GRADING & DRAINAGE PLAN

August 25, 2015

**Re: The Jones's Home
9000 Alameda Ave NE
Grading and Drainage
Engineers Stamp Date 8/20/2015 (C20D073)**

GRADING & DRAINAGE PLAN

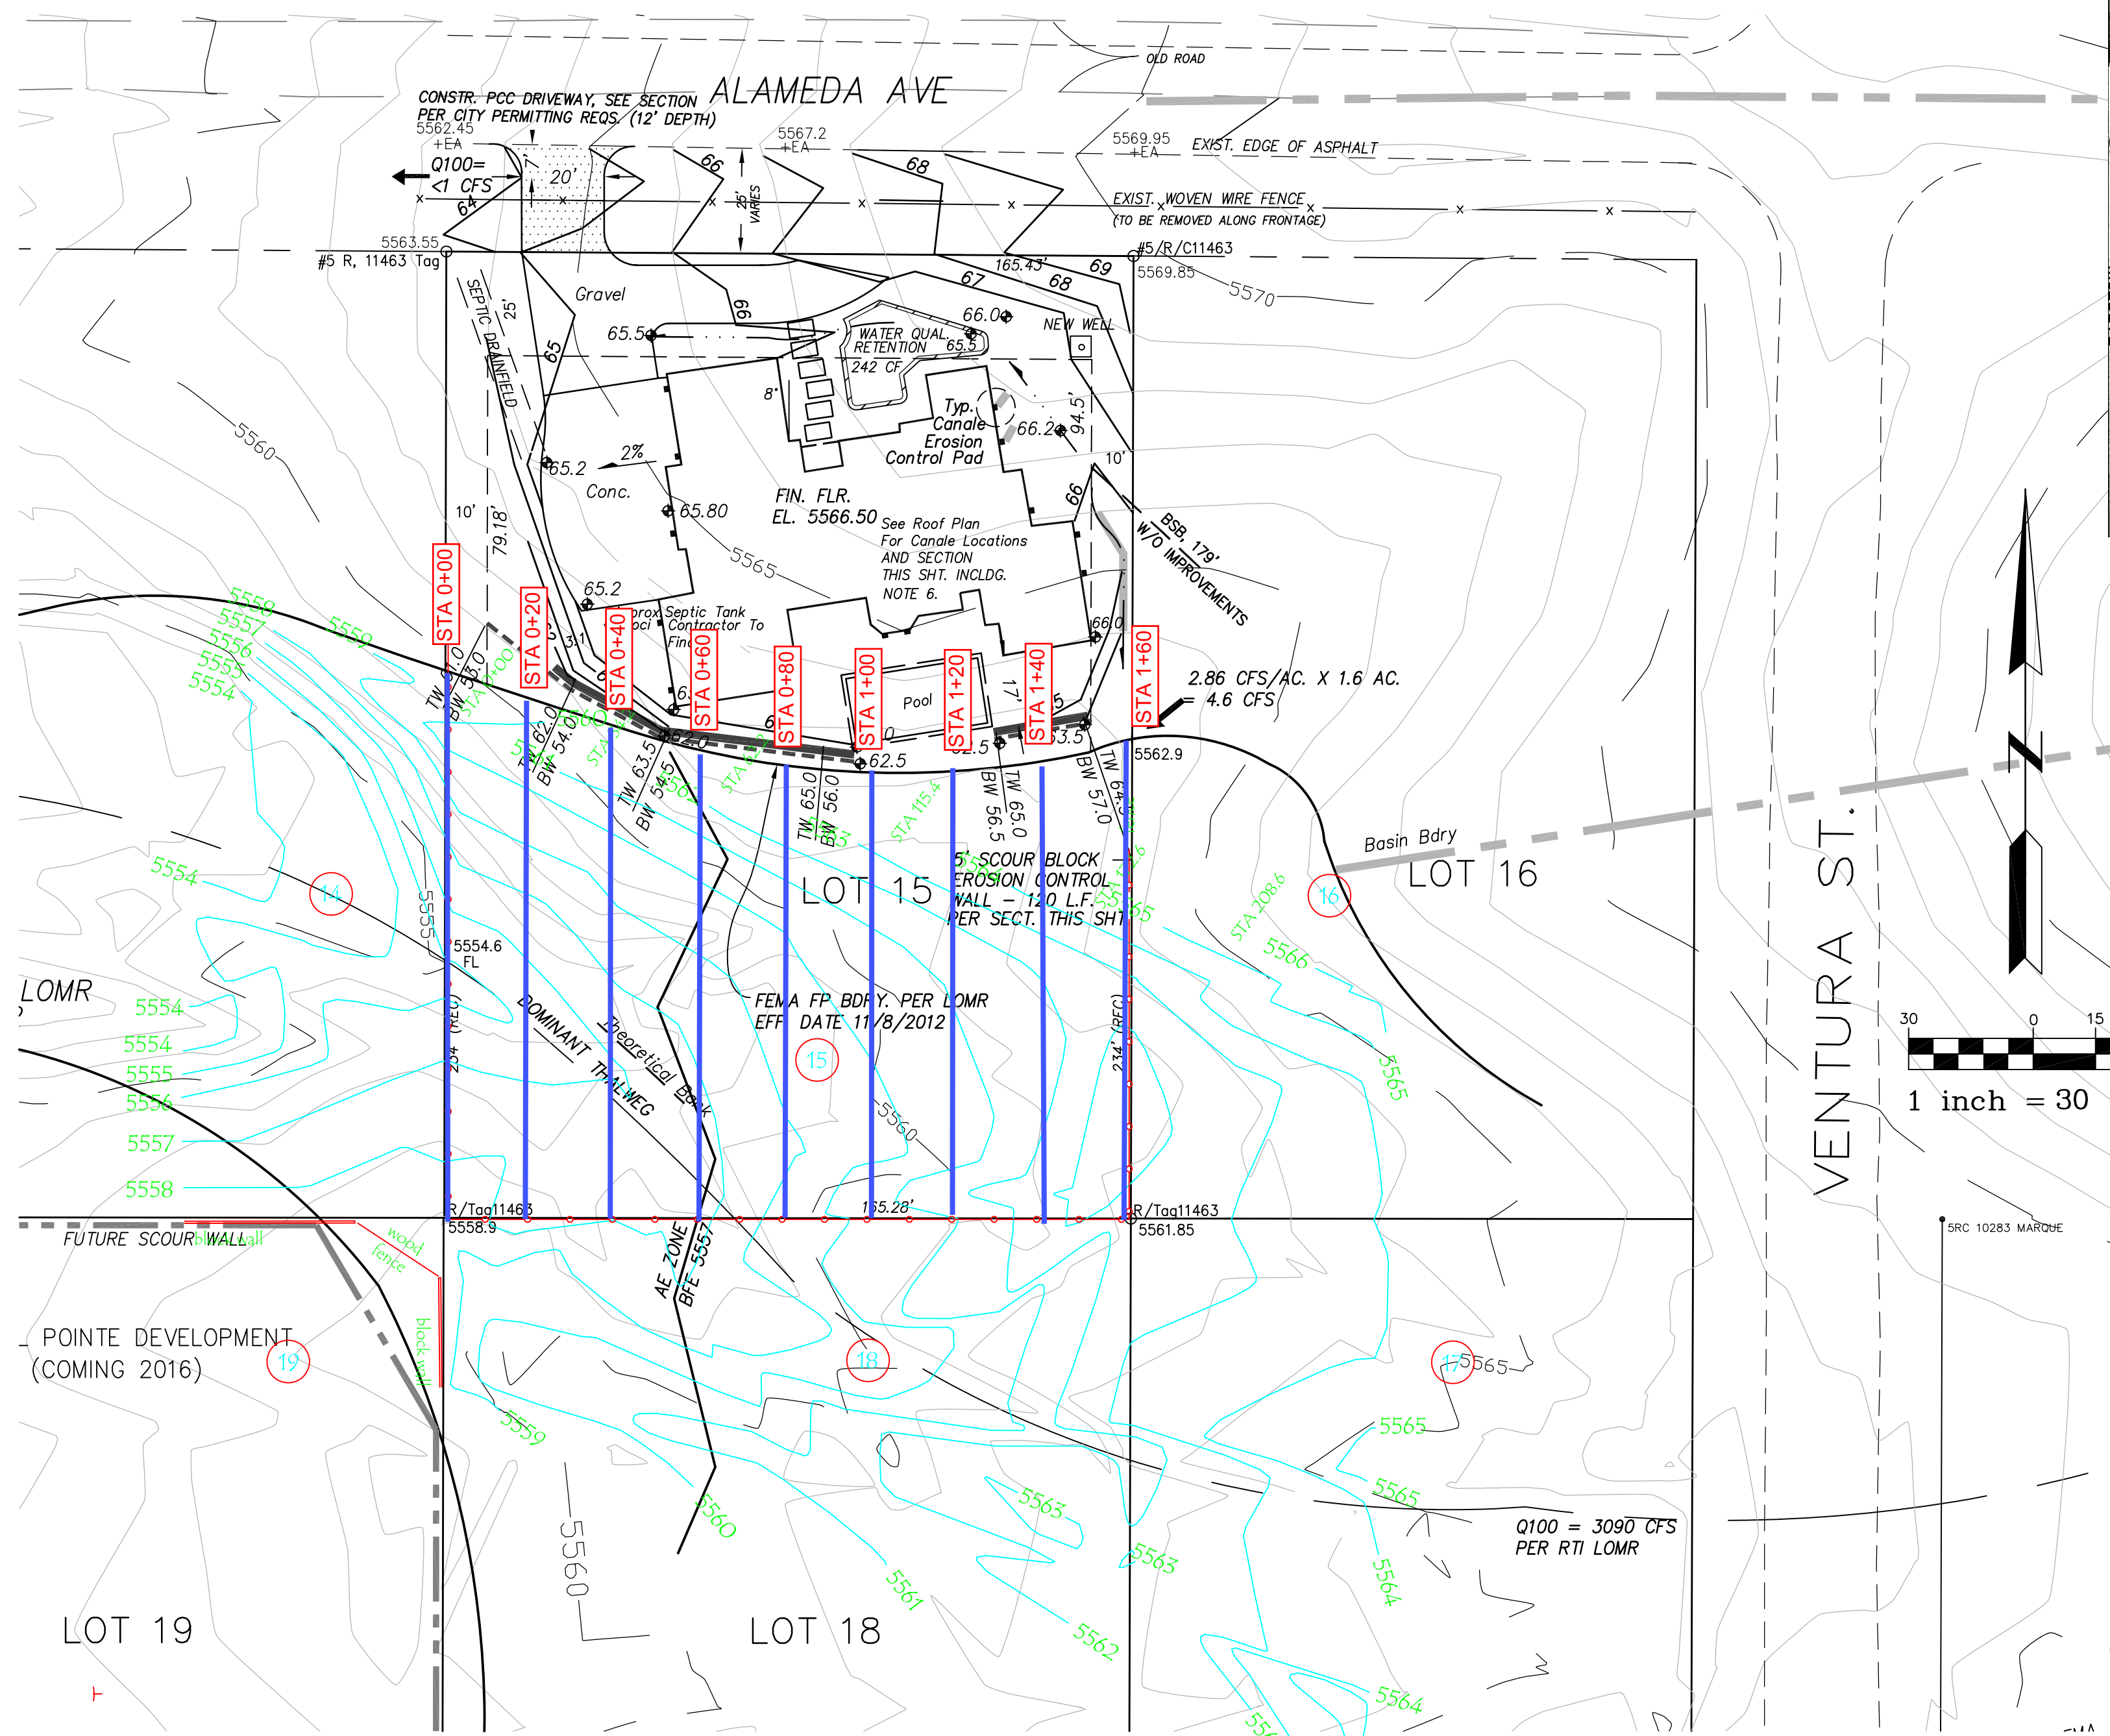
- Provide the location of the septic tank.
- Provide the specifications for the interlock retaining wall and scour wall system showing the tension fabric and other specifications.
- I calculated a Center Line Setback of 210', compared to your 190', please verify.
- Provide a concrete driveway up to the property line. Only one driveway is allowed off of Alameda.
- Provide reason for no scour wall to the south of the pool.
